From: ENVU Biodiversity and Land Use
Sent: 30 March 2026 10:48
To: Kerri Simpson
Cc: Planning ContactCentre
Subject: 2025/93514 at location land at, Brownhill Farm, Old Lane, Birkenshaw, BD11 2JL

I'm afraid that none of the matters I raised in my original comments have been addressed.
To be clearer:

Site Brown Hill Farm, Old Lane, Birkenshaw BD11 2JL	Client Jim Granger
Plan Proposed UKHAB Map	Author JE
Plan ref 01	Revision 01

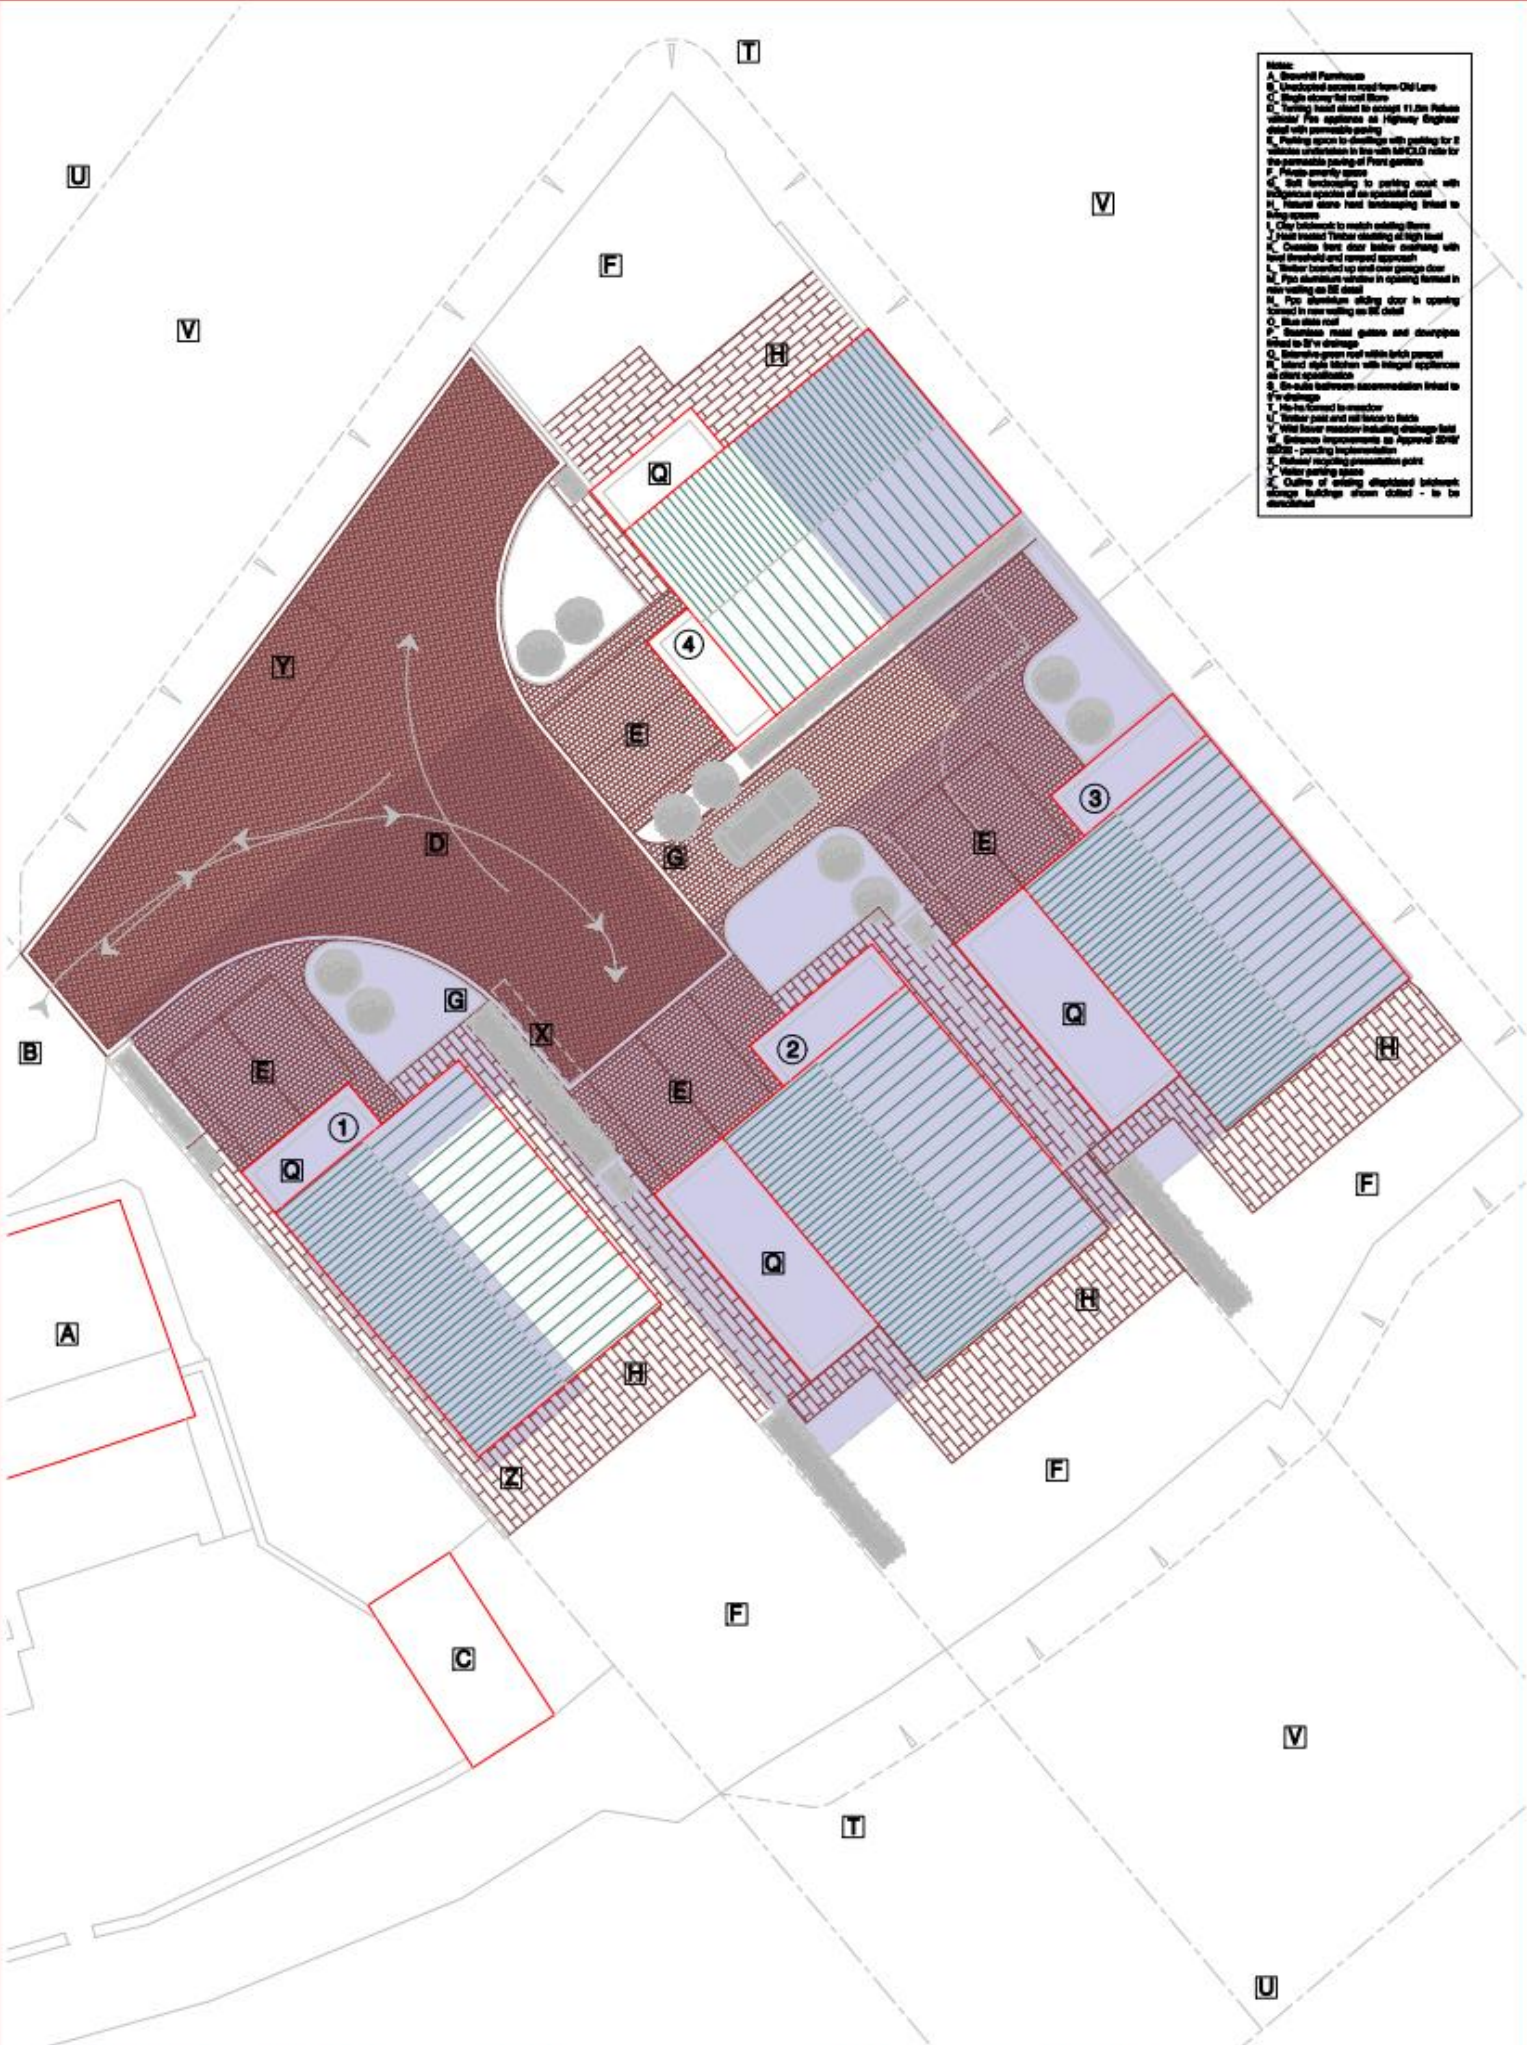
☒ For BNG – Further details on methodology, how the mitigation hierarchy was addressed; and post intervention plans are required for a complete metric.
